Address: 37 Moor Park Avenue Huddersfield HD4 7AL

Application number: 2025/91906	
What is the application for?:	Prior approval for enlargement of dwellinghouse by erection of additional storey
Address of the site or building:	35, Moor Park Avenue, Beaumont Park, Huddersfield, HD4 7AL
Postcode:	HD4 7AL

User comments

TITLE: FIRST FLOOR EXT'N & SINGLE STOREY REAR EXTENSION  
PROPOSED FLOOR PLANS & ELEVATIONS

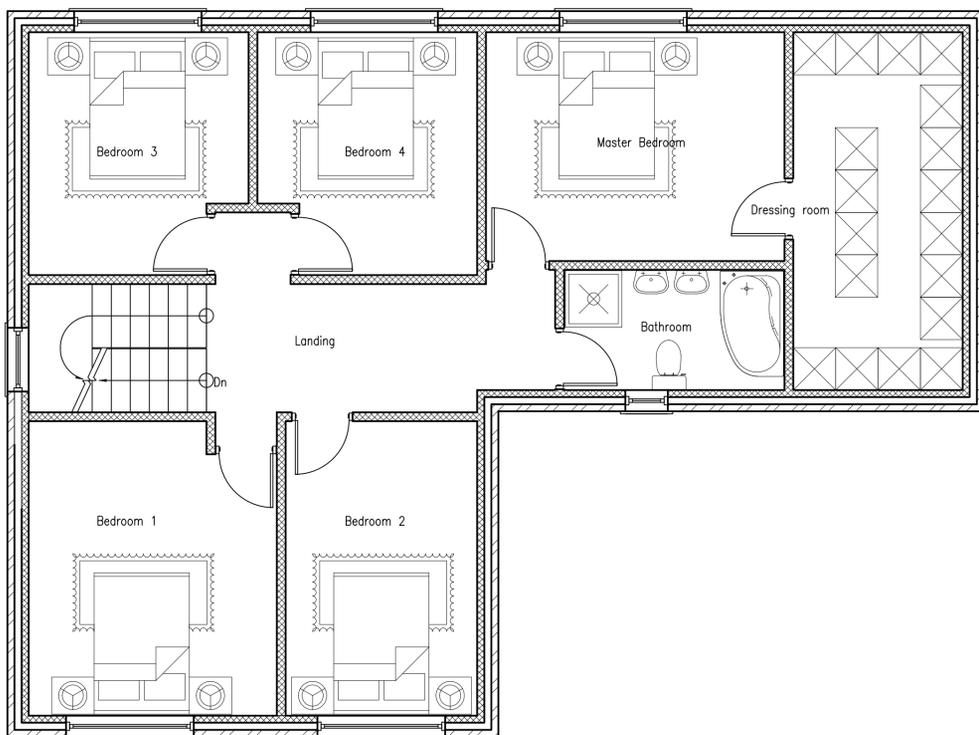
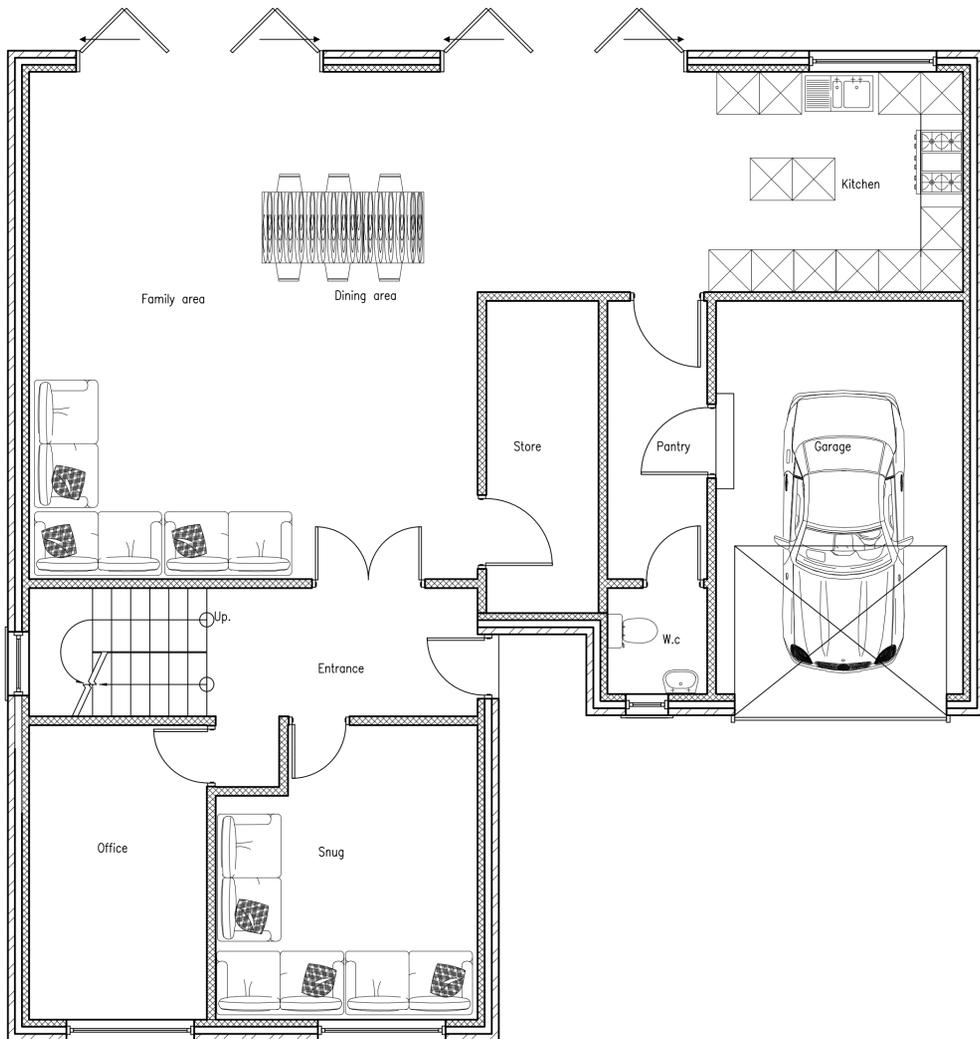
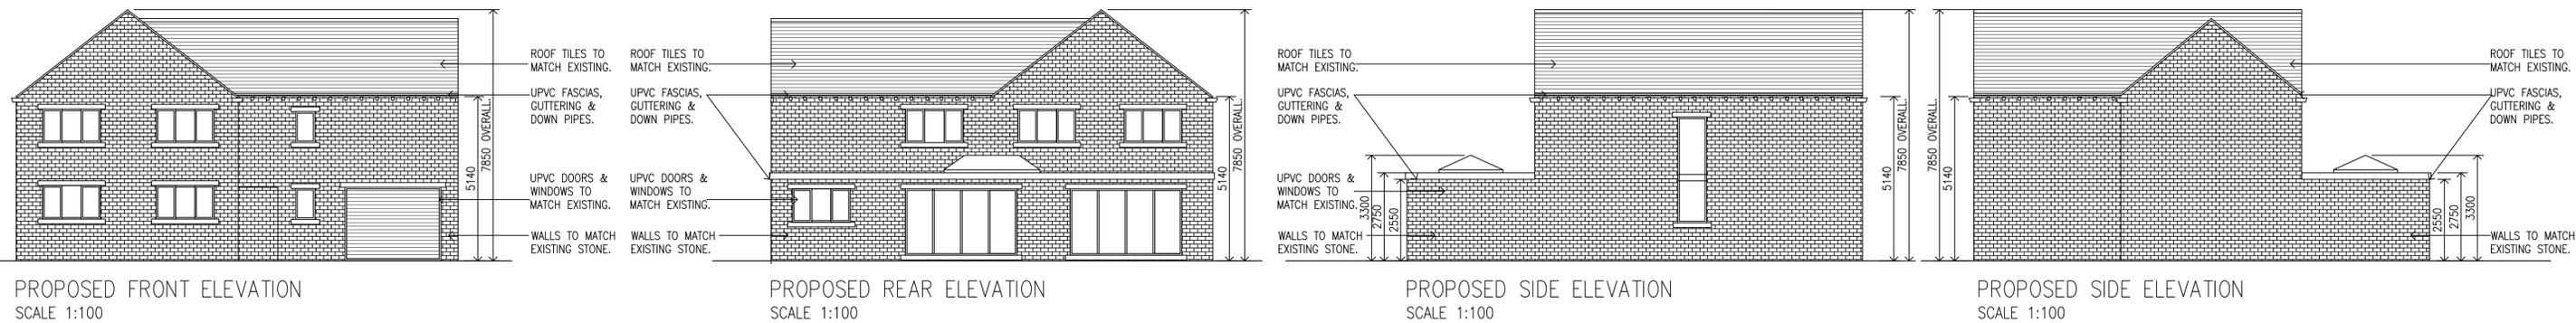
- a) Design and Impact. The design of this conversion is not in keeping with this part of the development, which incorporates 2 small cul de sacs of bungalows only. The proposed first floor extension by reason of scale, design and appearance would be incompatible and overly prominent within the neighbourhood. The original planning application (85/1952) to build houses on this site was refused and only subsequently approved when plans to build bungalows were submitted as an alternative.

- b) Privacy. Other properties on Delves Wood Court would become overlooked from the 1st story windows which would highly impact their level of privacy.

- e) Loss of Natural daylight. There would be a sizeable reduction of natural daylight to the properties within Delves Wood Court. In my property in particular, the reduction of natural light will not only impact the bedroom, which is situated at the front of the property, but also the home office, where my partner works full time. This room already has restricted natural daylight so any further reductions in this will cause a significant difference and would result in her needing to use artificial light throughout the day. The use of artificial light for extended periods is known to cause numerous issues with emotional and physical well-being.
